OXFORDSHIRE COUNTY COUNCIL'S RESPONSE TO CONSULTATION ON THE FOLLOWING DEVELOPMENT PROPOSAL

Application no: 22/00747/OUT

Proposal: Outline planning application for the development of up to 370 homes, public open space (including play areas and woodland planting), sports pitches and pavilion, drainage and engineering works, with all matters reserved (appearance, landscaping, layout and scale) except for vehicular and emergency accesses to Bicester Road.

Response date: 28th April 2022

Northern Access
1:500

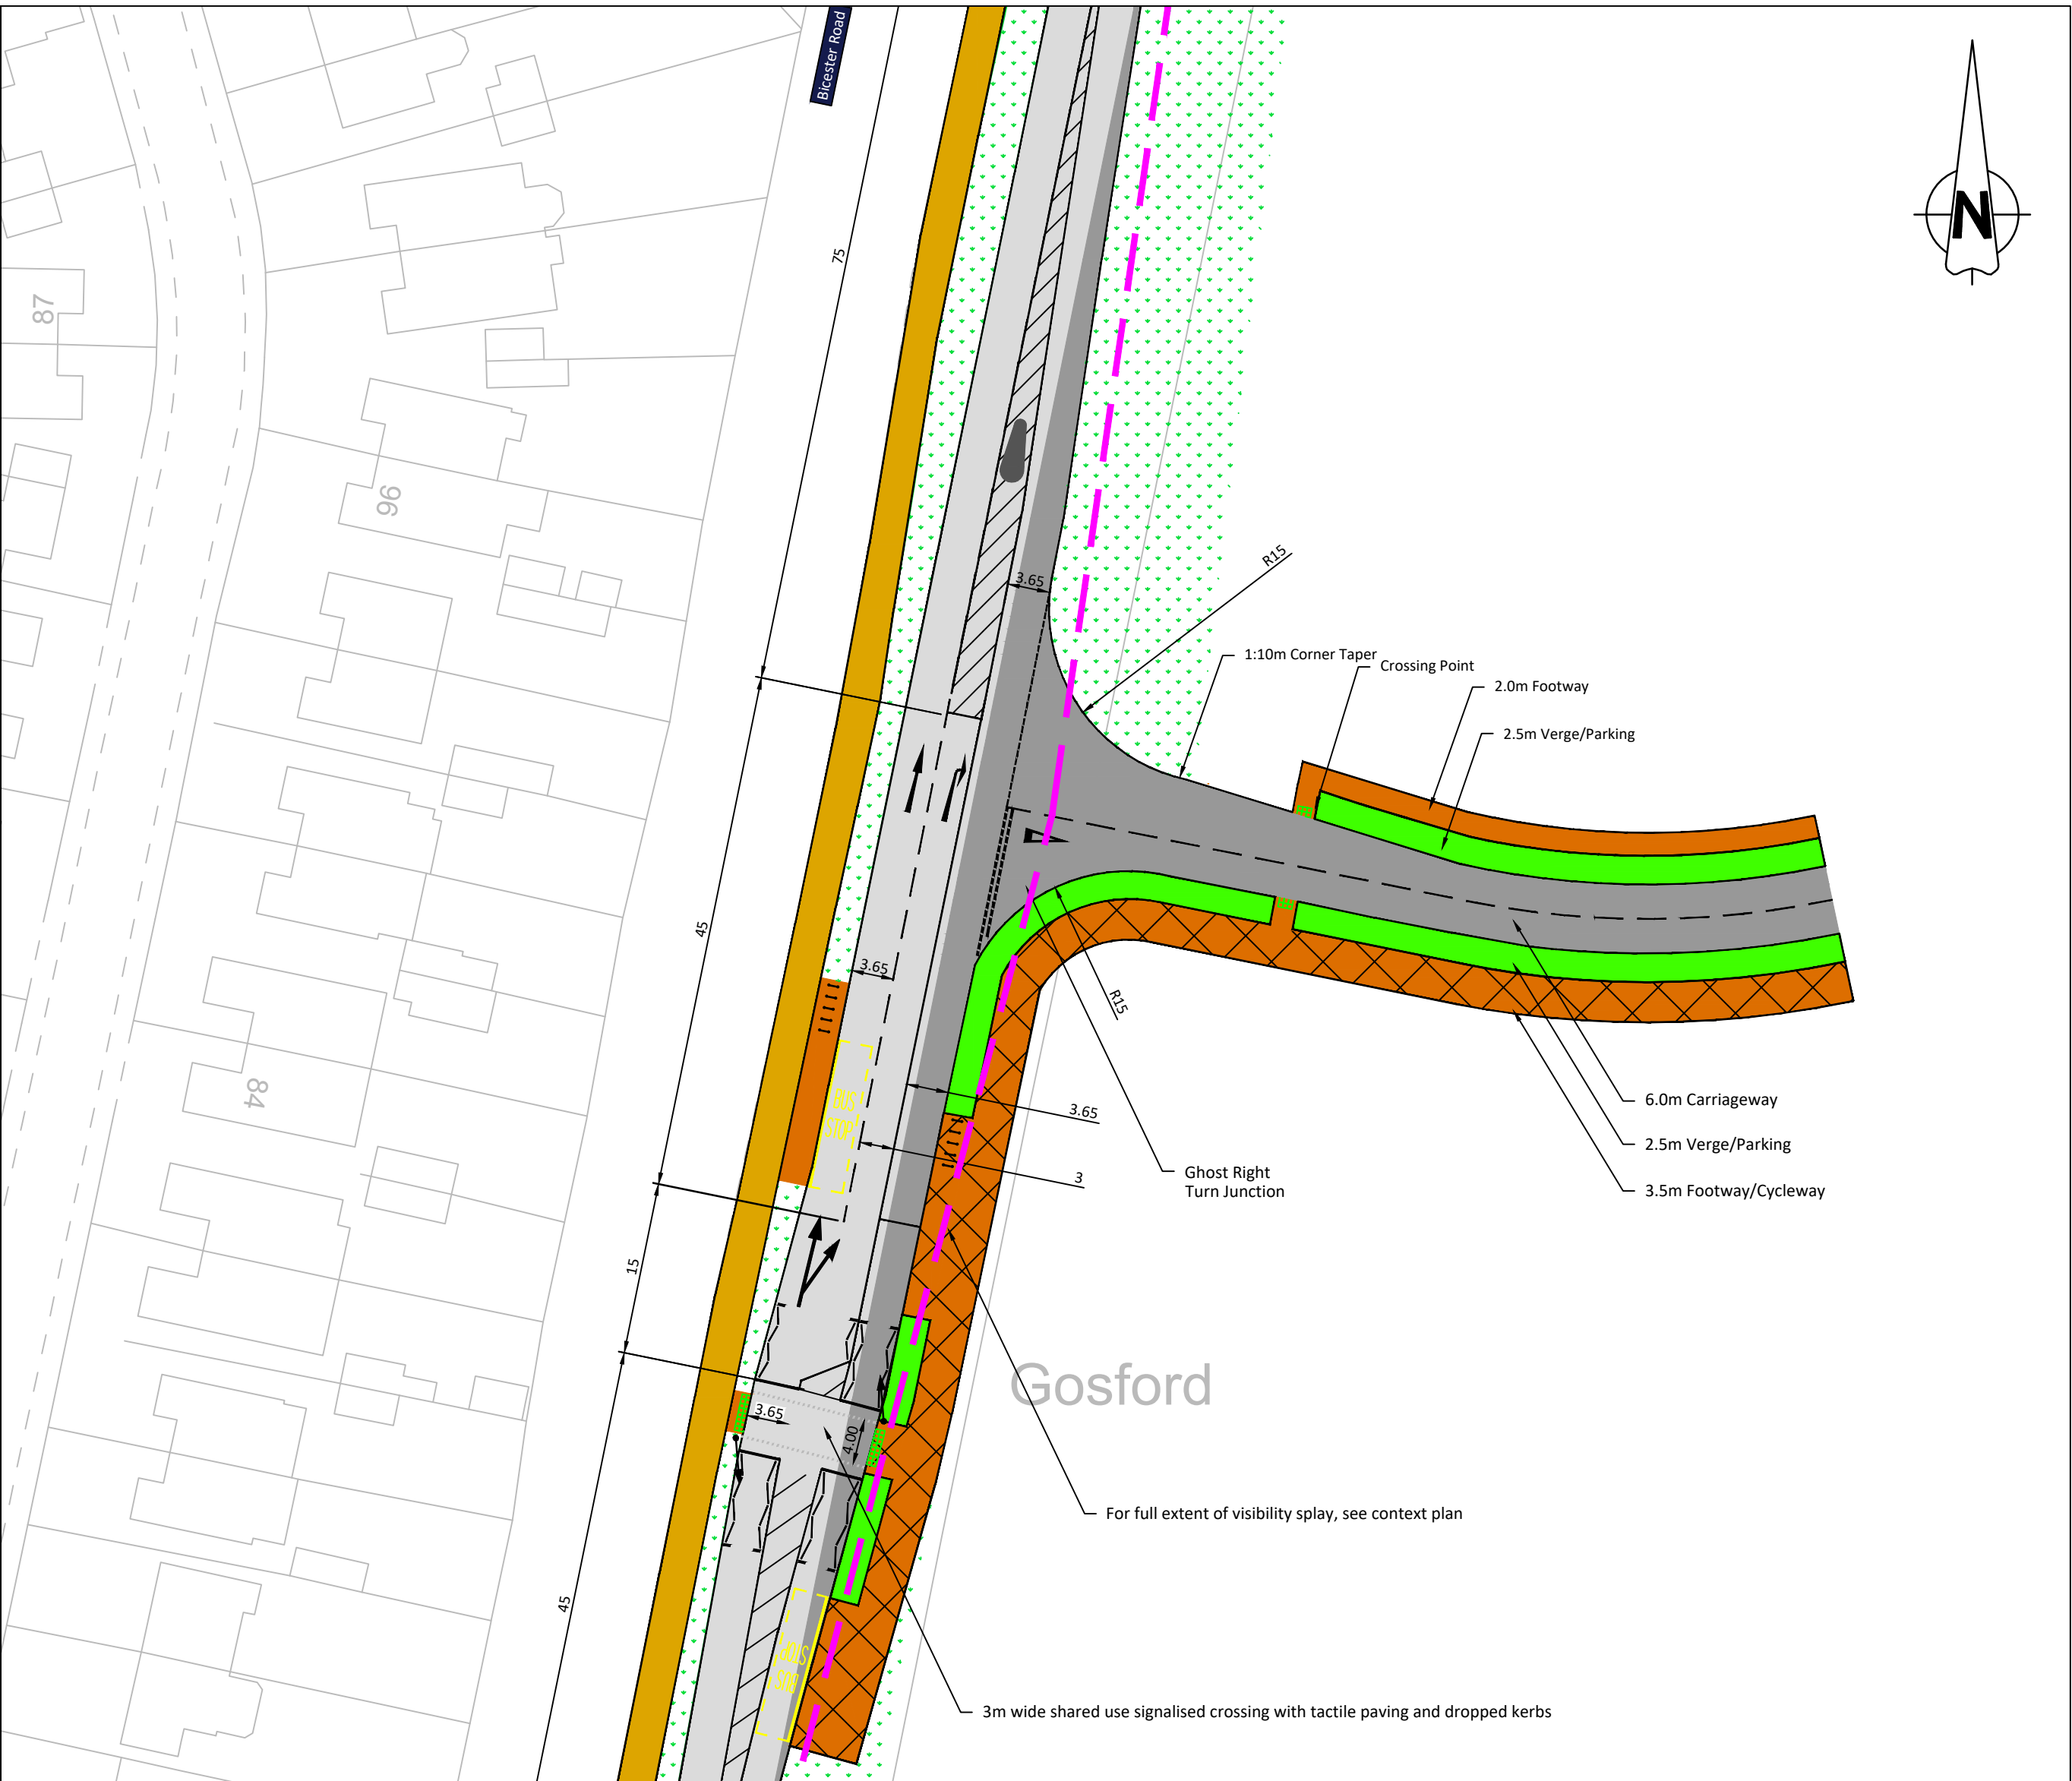
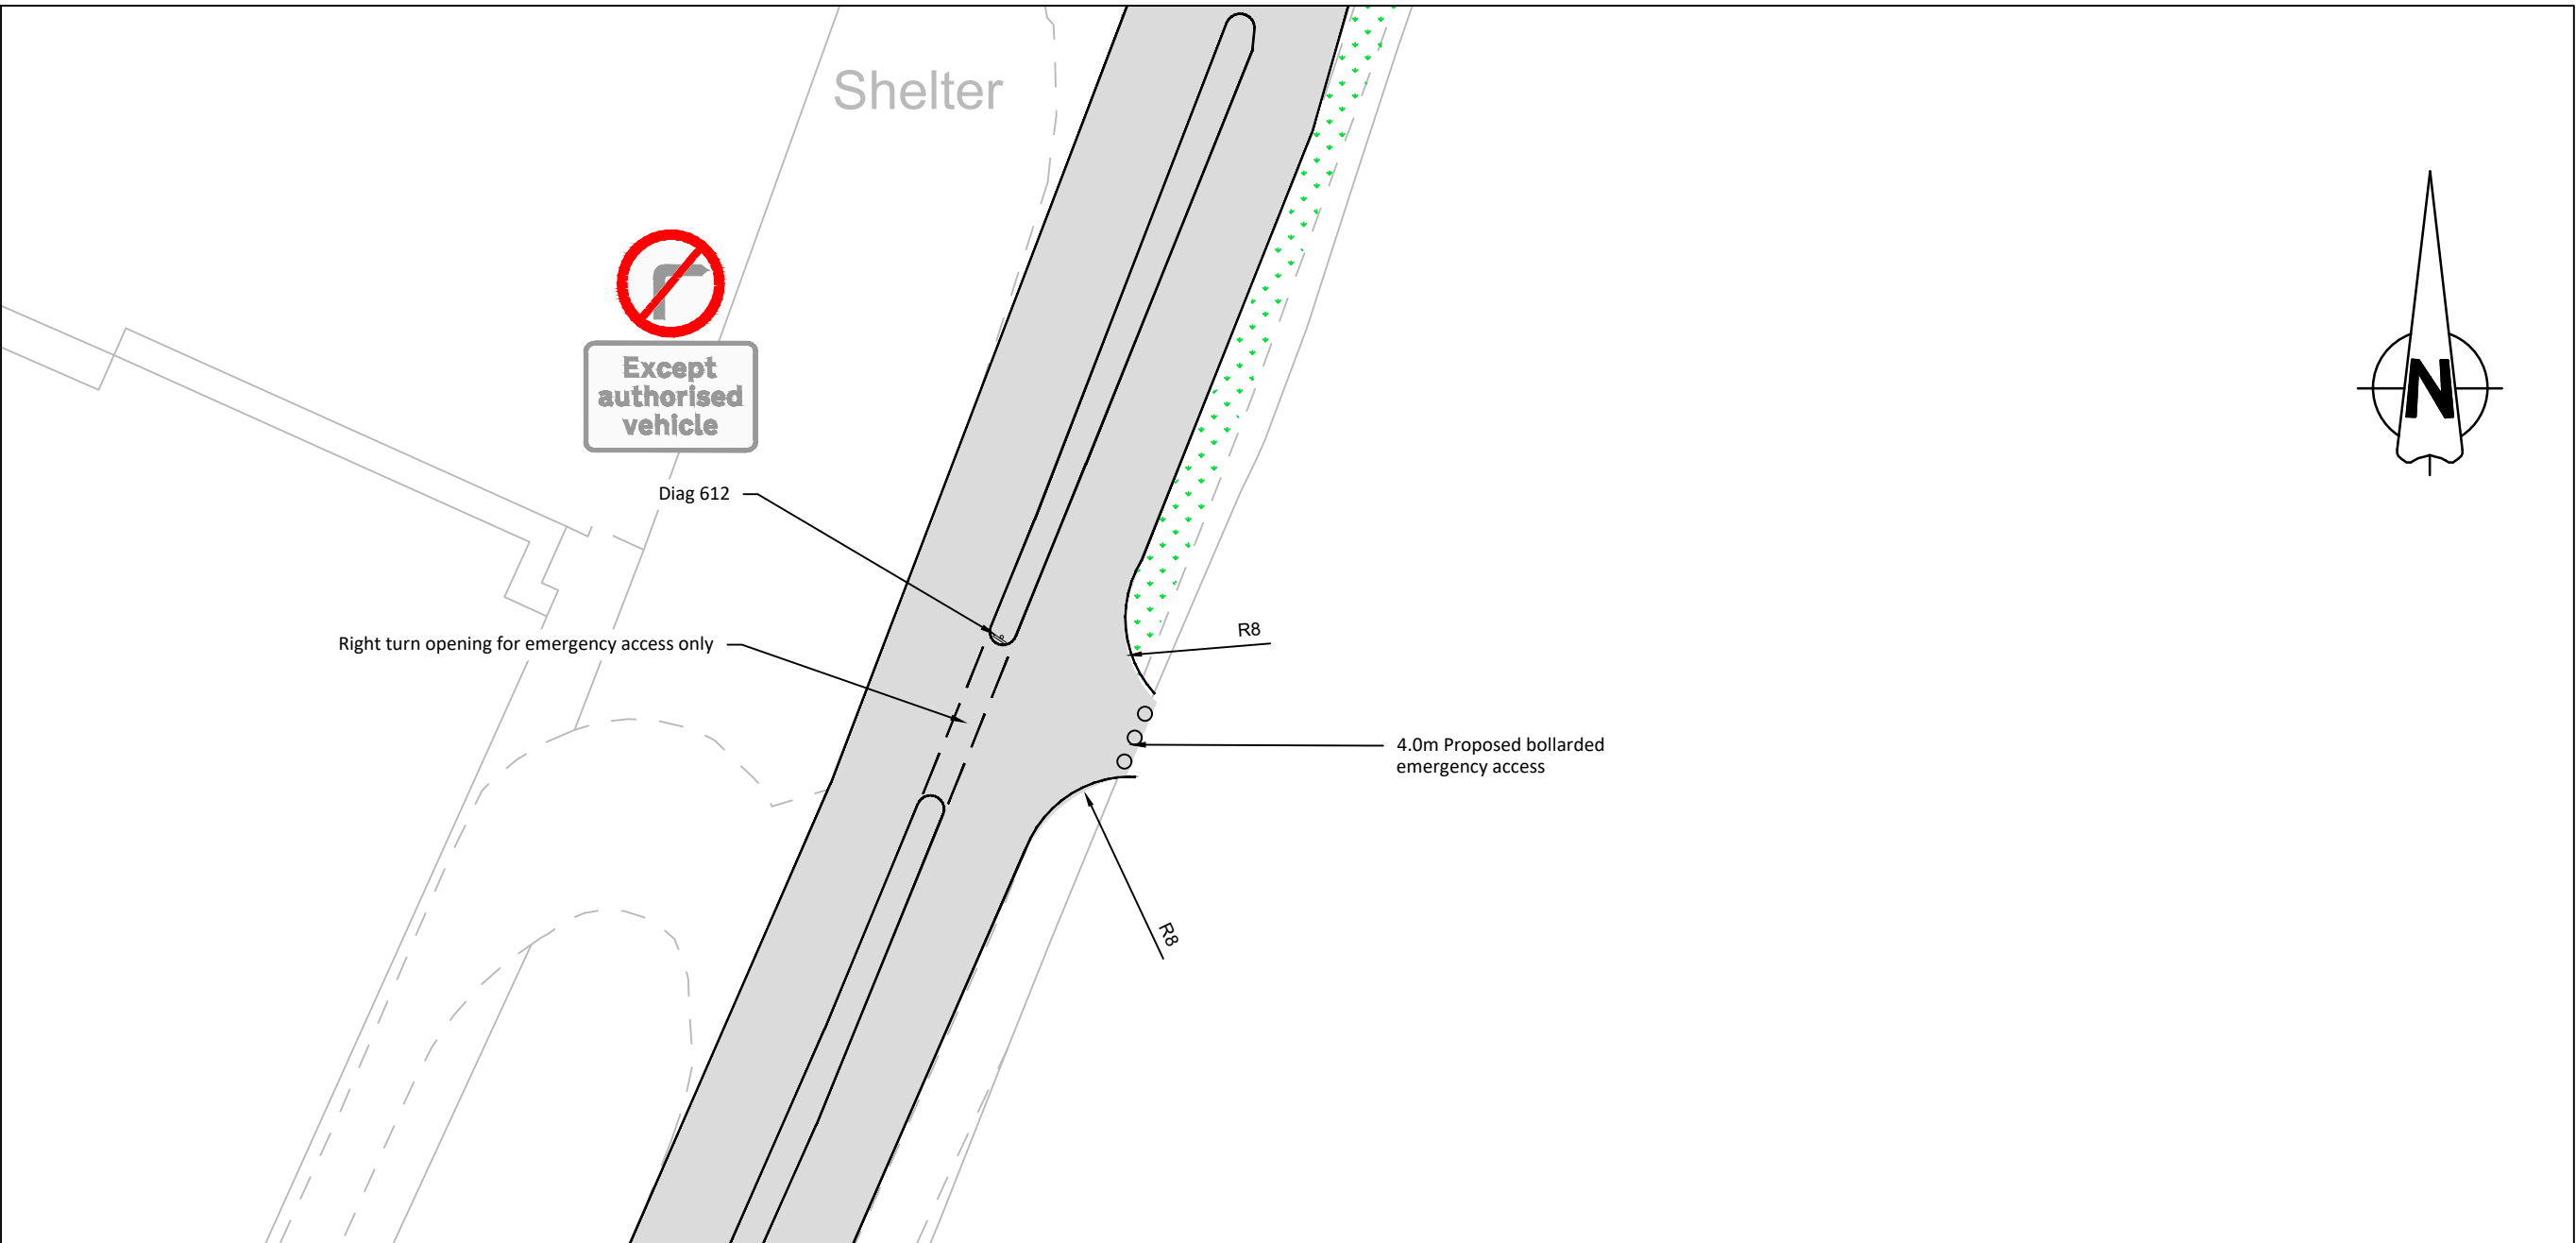
Vehicular Access – Bicester Road runs along the western frontage of the site and so, several accesses shall be taken off it. The principal vehicular access for the entire PR7a allocation is proposed via a T junction ghost right turn off Bicester Road as shown by Drawing no. 10669-SK-05 Rev A.

The vicinity of the site access along Bicester Road is fairly straight. The proposed access thereby benefits from adequate visibility splays although the splays need to be indicated on the access plan. Although not part of this submission, a second point of access into the parcel of land controlled by Hill shall be taken from a simple T junction off Bicester Road north of the cemetery which shall be delivered via a second planning application.

Interrogation of the TA and indeed other documents fails to reveal the swept path drawings at any of the site accesses. The swept path drawings must be submitted to show that the site accesses can safely accommodate expected vehicles. **Further information required**

Emergency Access – This access is observed to be emerging onto Bicester Road at a point where the carriageway is dualled. This would limit the emergency functionality of service vehicles accessing from the south where it will be impossible for right turn manoeuvres to be quickly made into the site. A central reserve opening shall therefore

Construction Access – It is assumed that construction traffic would utilise the principal vehicular access. This access if it is intended for construction purposes shall not be acceptable until submission is made of a swept path analysis for a 12m long rigid truck and a 16.5m long articulated truck.
